Reference No:	2026/44/91286/E
Site Address:	2, Elm Street, Skelmanthorpe, Huddersfield, HD8 9BH
Description:	Discharge of details reserved by conditions 4 (dilapidation survey), 5 (Phase I Desk Study Report), 6 (Phase II Intrusive Site Investigation Report), 7 (Remediation Strategy), 8 (accordance with the Remediation Strategy), 9 (Verification Report), 10 (ecological enhancement measures), 11 (waste collection) and 14 (materials) on previous permission 2025/90583 for erection of rear dormers, raising of roof height and alterations to workshop to form dwelling
Recommending Officer:	Elenya Jackson

DECISION – DISHCHARGE OF CONDITIONS – SPLIT DECISION

**Officer Report
2026/91286**

Drawing Title:
Proposed Location & Site Plan

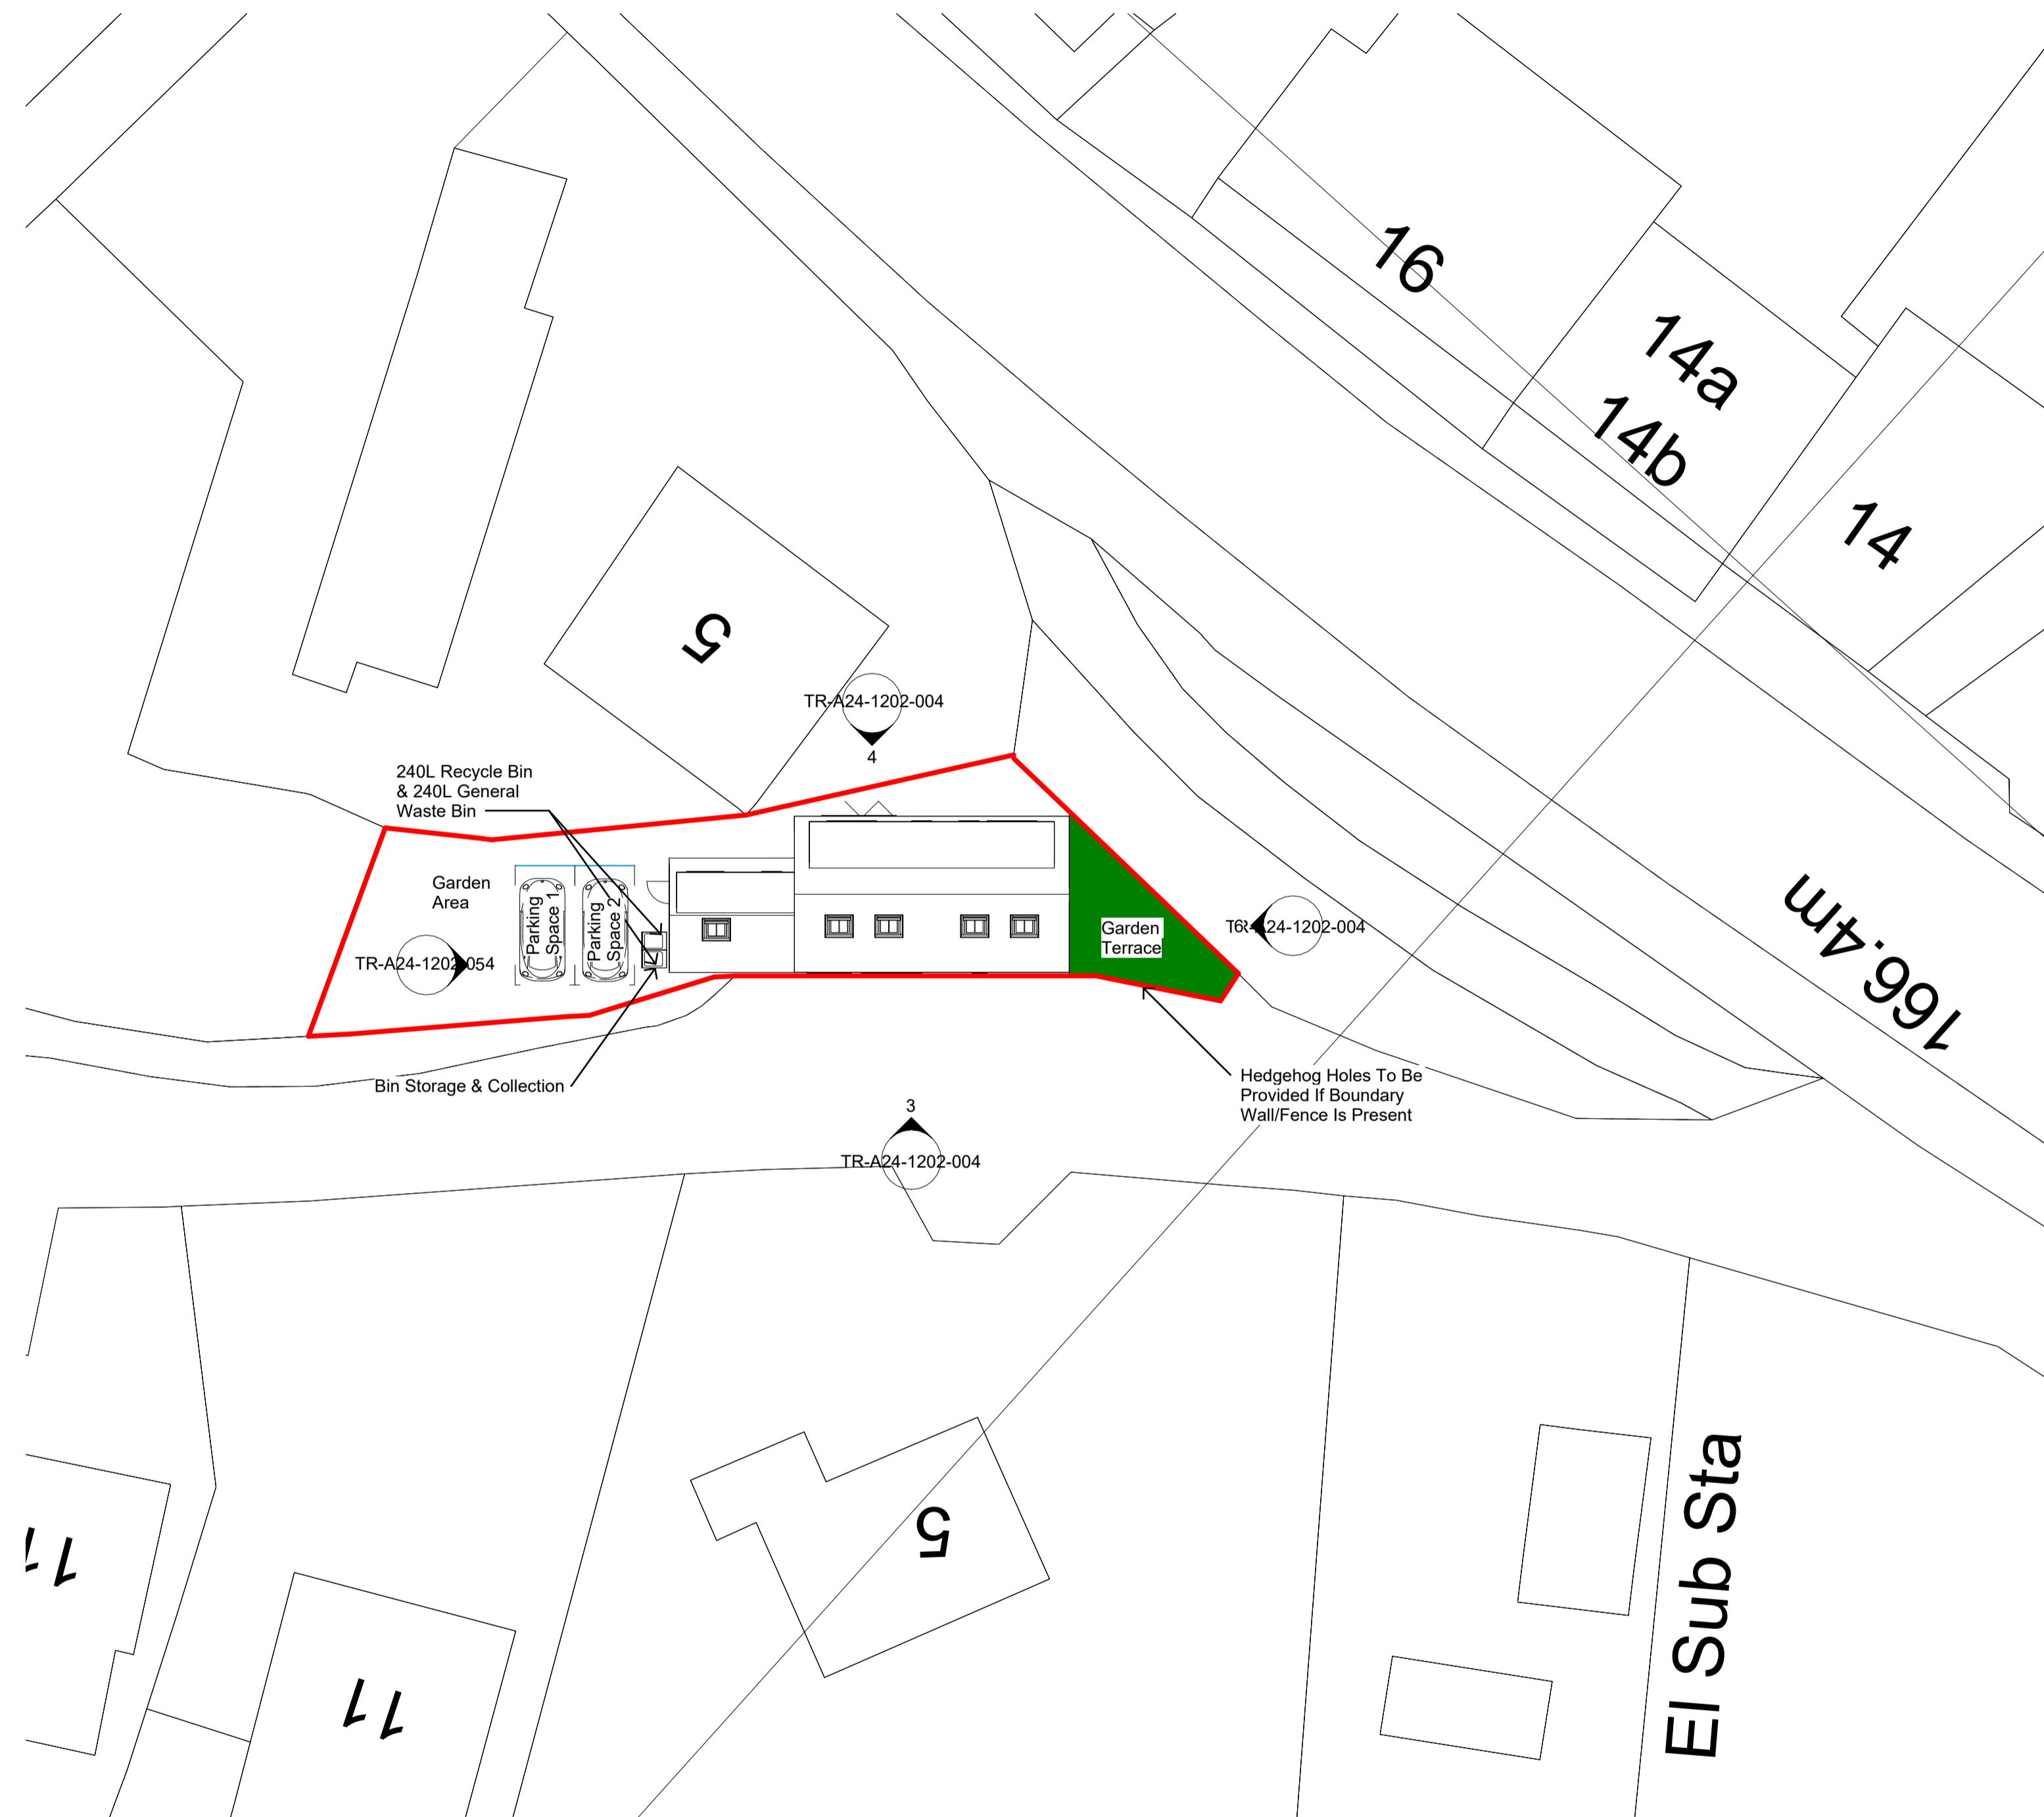
Officers have consulted with KC Ecology on the application; no details have been provided in support of condition 10 and the boundary treatments on site have not been confirmed nor the location of a swift box. Therefore, condition 10 cannot be considered satisfied and must remain outstanding at this time.

Officers have consulted with KC Ecology on the application; no details have been provided in support of condition 10. The boundary treatments on site have not been confirmed nor the location of a swift box. Therefore, condition 10 is not satisfied and cannot be discharged.
